**WELWYN HATFIELD BOROUGH COUNCIL – DEVELOPMENT MANAGEMENT**  
**DELEGATED REPORT**

**APPLICATION No:** S6/2013/2495/FP

**SITE ADDRESS:** 87 The Ridgeway, Cuffley, Potters Bar

**DESCRIPTION OF DEVELOPMENT:** Erection of a single storey rear extension and front canopy

project Proposed ground floor rear extension and front canopy	
site 87 The Ridgeway Cuffley	
date August 2012	scale 1:100
JOHN PERRIN & CO BUILDING SURVEYORS 885 Green Lane, Wincoburn Hill, London N21 3JG Tel: 0208 364 8334 Fax: 0208 292 8195 © John Perrin & Co 2012	
drawing number 2334/5

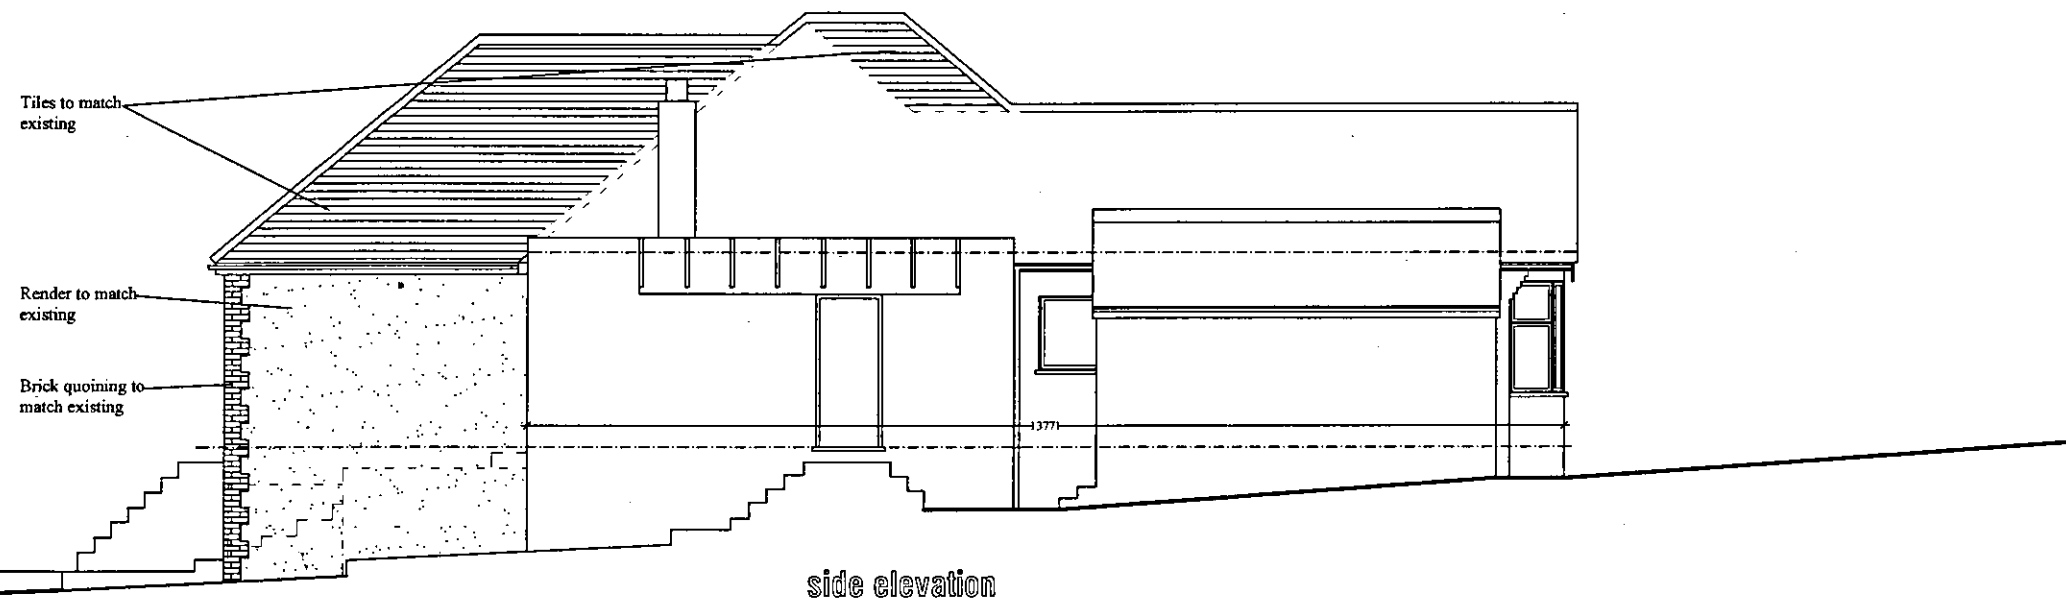
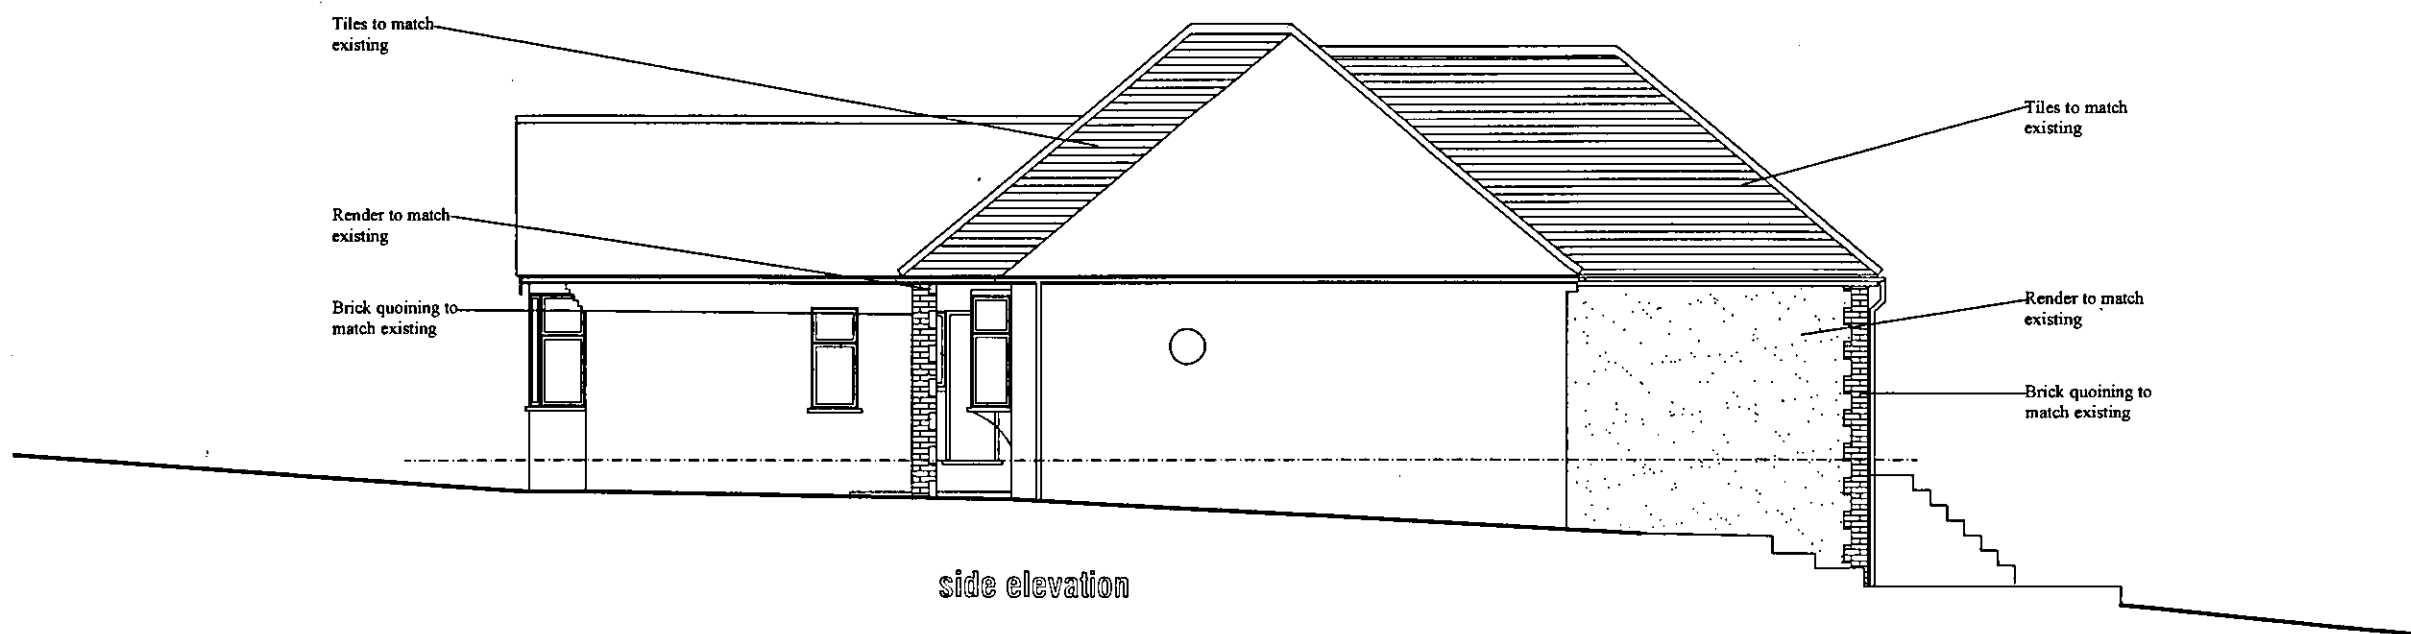
Despite being sited to the rear of the property, the proposed extension would still be visible from the streetscene of The Ridgeway. The land slopes away to the rear of site meaning that any alteration would have more of a visual impact on the pattern of

development in the surrounding countryside. This extension to the rear would span across the entire width of the original property and have a hipped roof design. It is considered that the by virtue of the rear extension's width and roof design, an excessive amount of bulk and mass would be added to the rear of the property. The roof alterations proposed at the front of the dwelling do not increase the maximum dimensions and despite the prominent siting, the dimensions and additional bulk is considered to have a limited impact upon the appearance of the streetscene.

b) Local policy requires that extensions should form as a subordinate feature and not impact on the character and appearance of the host dwelling and the locality. The rear extension would have a crown top roof. Although this roof form doesn't feature on the existing dwelling, it is commonplace of other properties in the surrounding area and so reflects the local character. However, in this instance, the overall width of the rear extension, and the bulk of the roof when considered with the downward slope of the land, towards the rear of the site, would fail to make the extension appear subordinate to the host dwelling.

Furthermore the alterations to the front roof slope to create a canopy would be sited in a prominent position on the property and relatively visible in the streetscene. However, the overall scale of this element of the proposal is considered to be limited and therefore would not unduly impact the appearance of the host dwelling or The Ridgeway streetscene.

2. The proposed rear extension by virtue of its scale, siting and roof bulk, when considered with the downward slope of the land, would fail to form a subordinate addition to the rear of the property that would complement the host dwelling, the character of the immediate streetscene and the Northaw Common Parkland Landscape Character Area. The proposal is therefore contrary to the NPPF, policies GBSP2, D1, D2, RA10 of the District Plan and the Council's Supplementary Design Guidance.

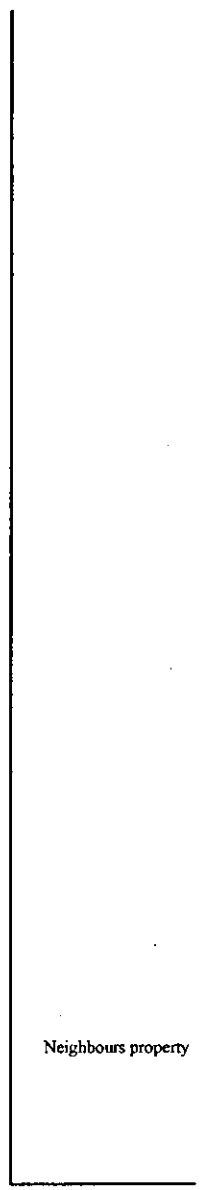
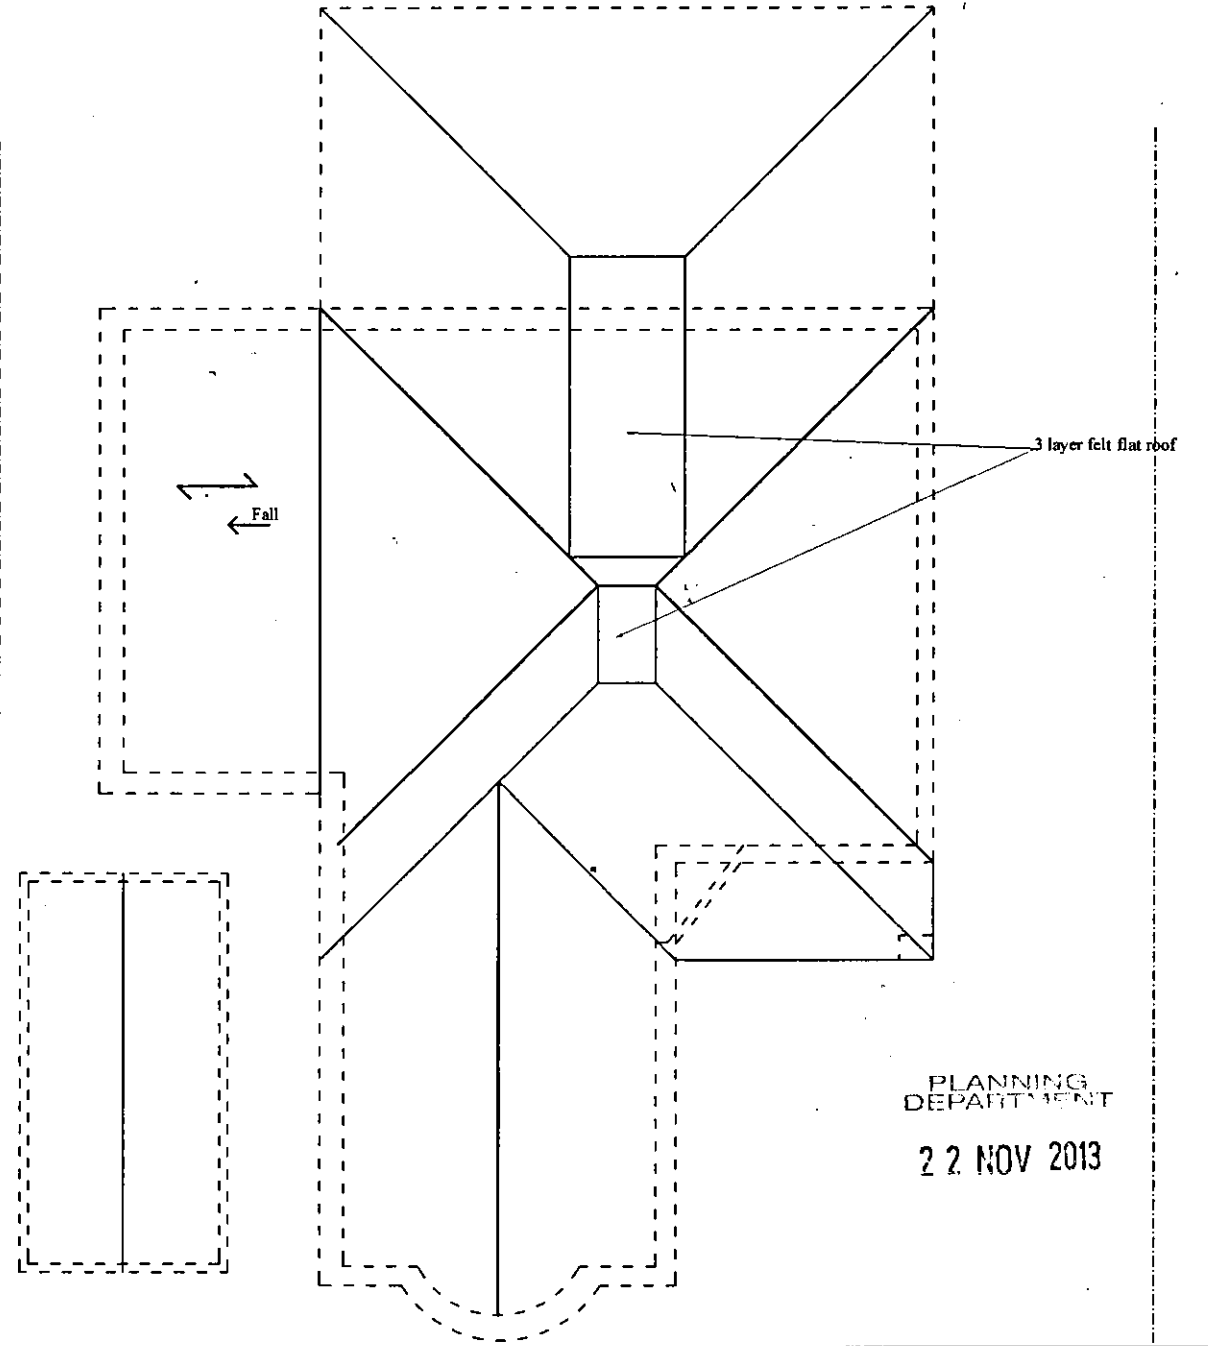
When compared to the original dwelling, the resultant property would be 3m wider than the original, an increase of 37%. Additionally, the extension would increase the maximum depth of the property by 4.1m, an increase of 30%. The roof of the proposed rear extension would be set down from the ridge by 0.3m to ensure that the resultant property would not be any higher than existing.

As this property only has one habitable level, the values of the calculated footprint and the overall floorspace are the same, however the proposed extension to the rear would increase this figure by 51.9m from the original property, an increase of 55%. Accumulatively, the existing and the proposed extensions would account to a disproportionate increase in size to the dwelling in relation to the original property.

The fundamental character of Green Belt land is its openness, and National policy has the intention to preserve the impact on openness. The proposed extension would be sited to the rear of the property and be of the same width of the original dwelling. The extension's 8.1m width and proposed roof design is considered to increase the bulk and mass of the property, reducing the openness of the site. However, little weight is afforded to this consideration as even though the sense of openness would be reduced, sufficient visual gaps either side of the property would be preserved to maintain a degree of openness. The roof alteration to the front is also not considered to have an undue impact on openness, by virtue of the limited scale of development.
